**Post Point CHN 215**  
**Hertfordshire County Council**  
**County Hall, Pegs Lane**  
**HERTFORD SG13 8DN**

Date 2 December 2022

**RE: 6/2022/2300/COND – Former Volkswagen Van Centre, Comet Way, Hatfield, AL10 9TF**

**Recommendation:**

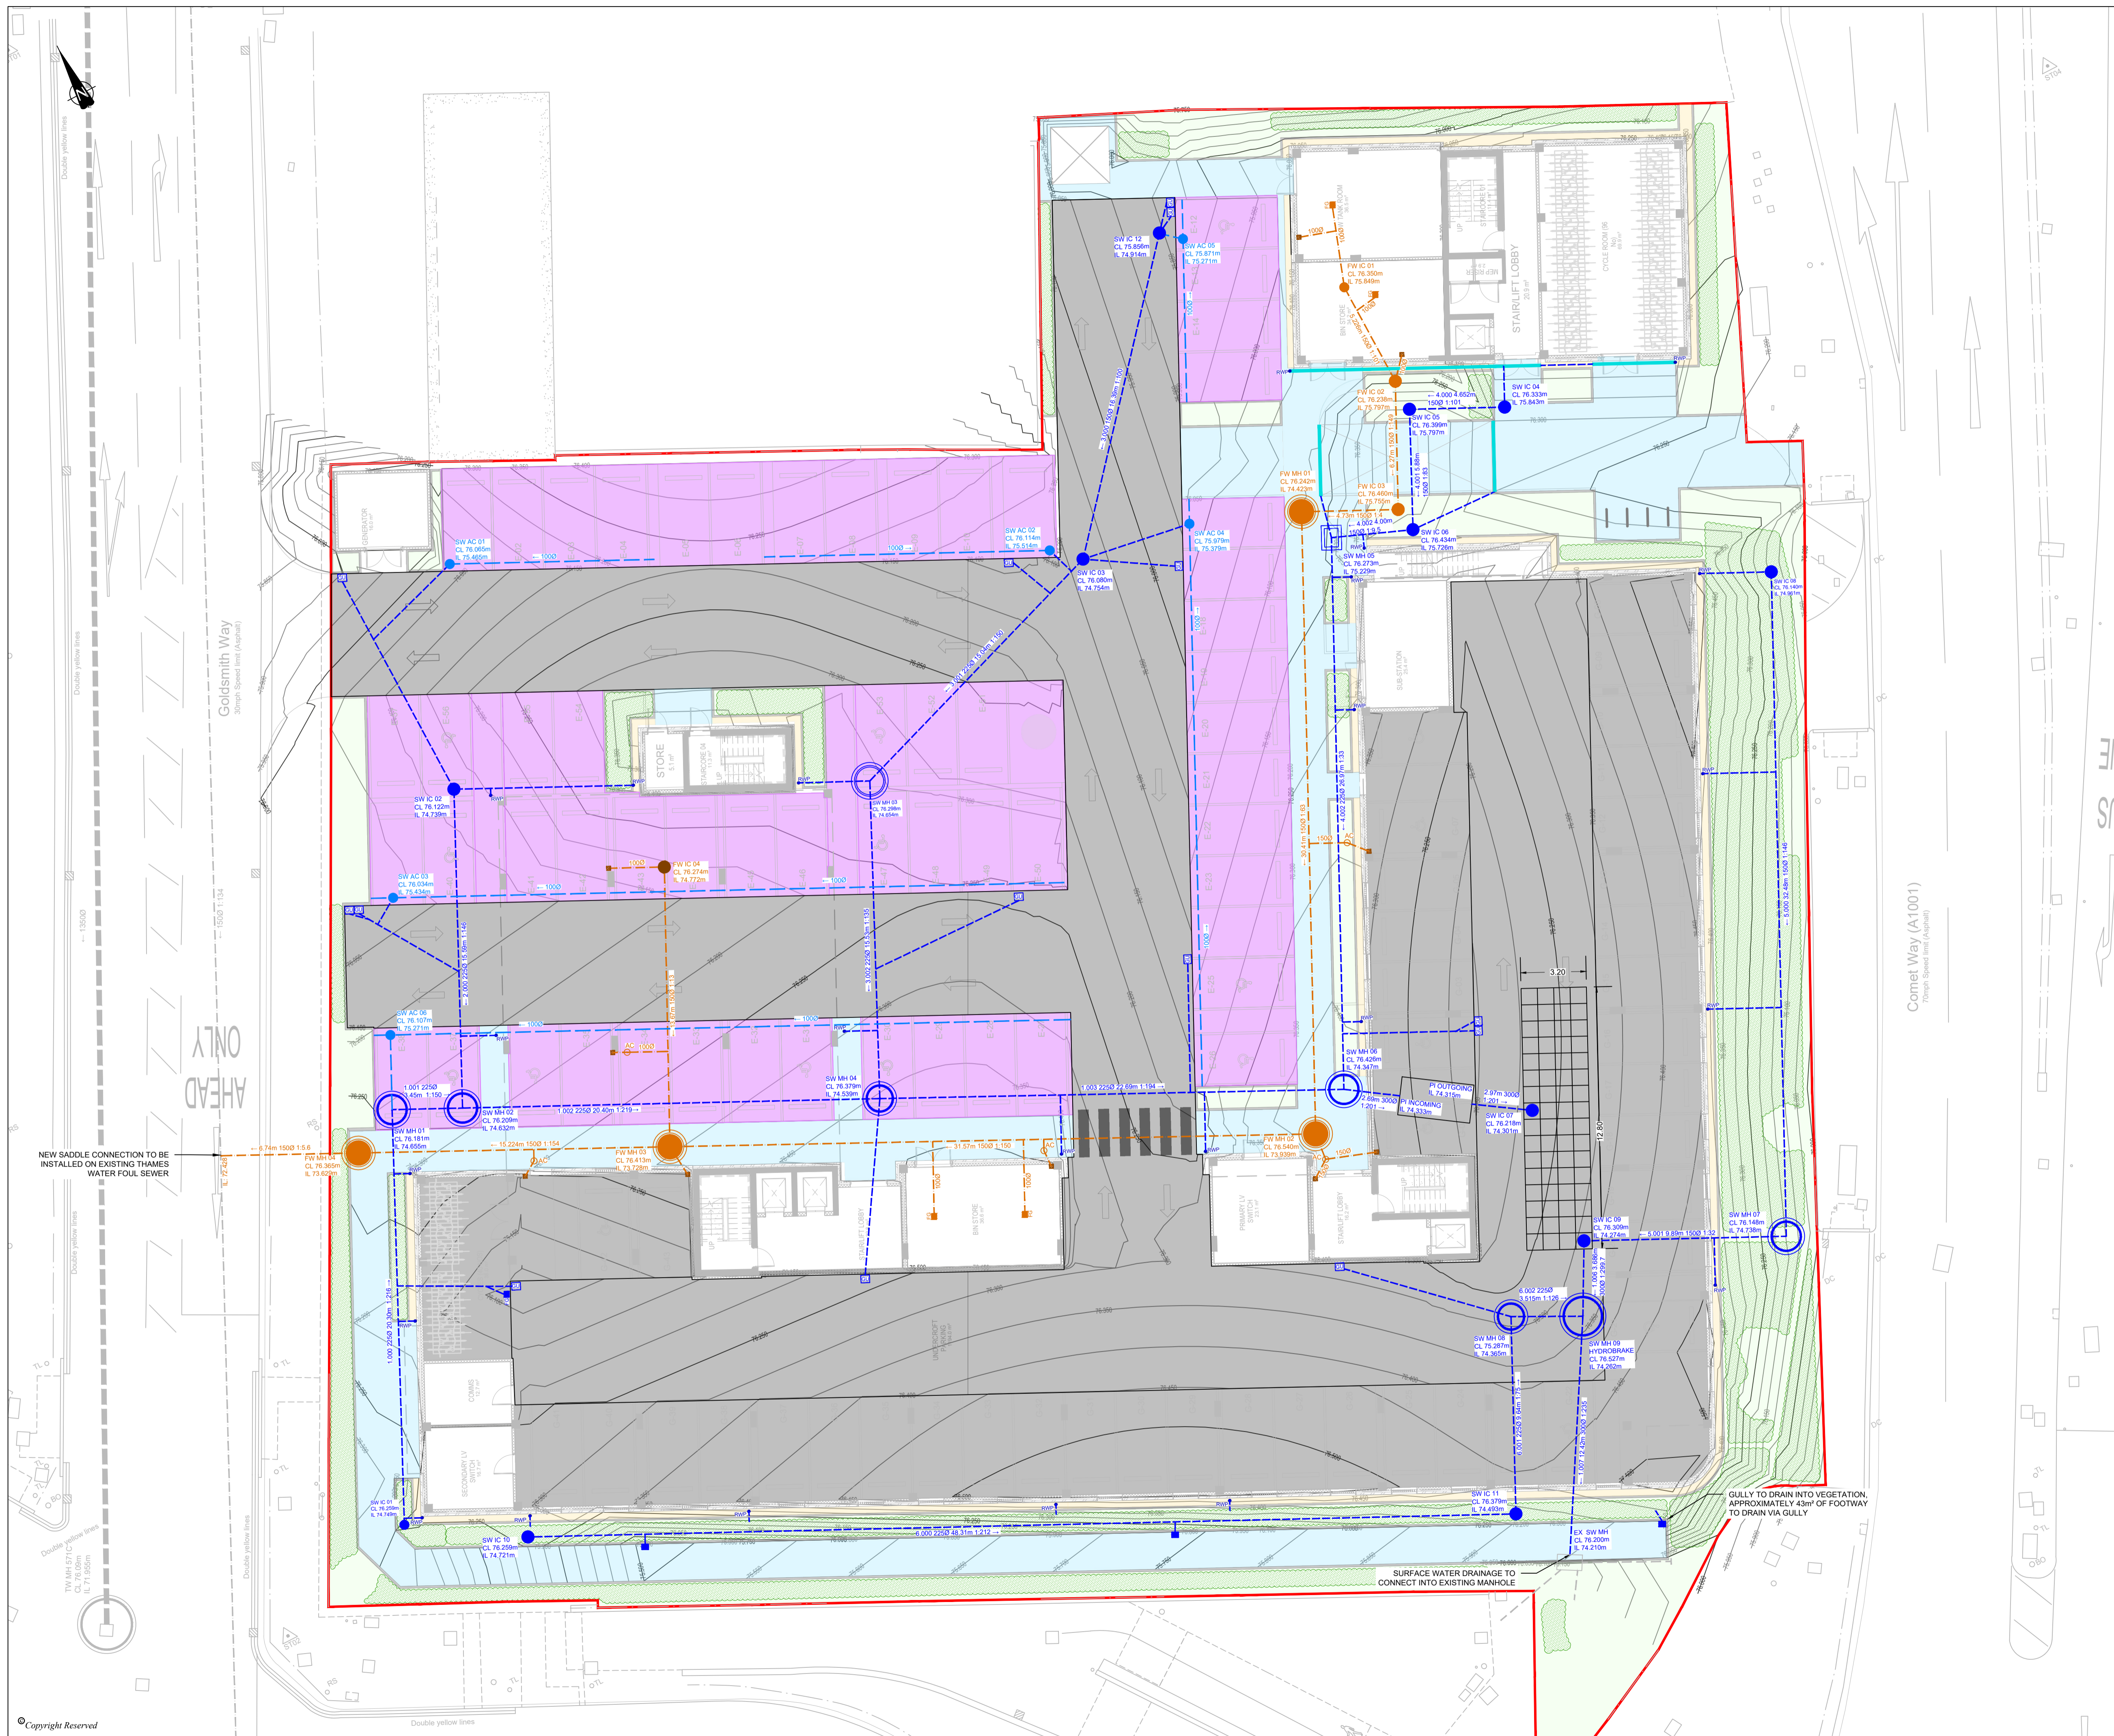
The LPA should ensure they are prepared to accept an increase in discharge rate from the originally stated 2l/s to 2.8l/s. The LPA may wish to require justification for this increase rate from the applicant.

The LPA should note that Condition 5 stipulates a discharge rate of 2l/s. The Condition 5 Compliance Report A, Jasper Kerr, September 2022 provides a discharge rate of 2.8l/s. The LPA should assure themselves that this deviation from the original discharge rate provided will not have a detrimental impact on the functionality of the drainage system for the site. Justification from the applicant may be required.
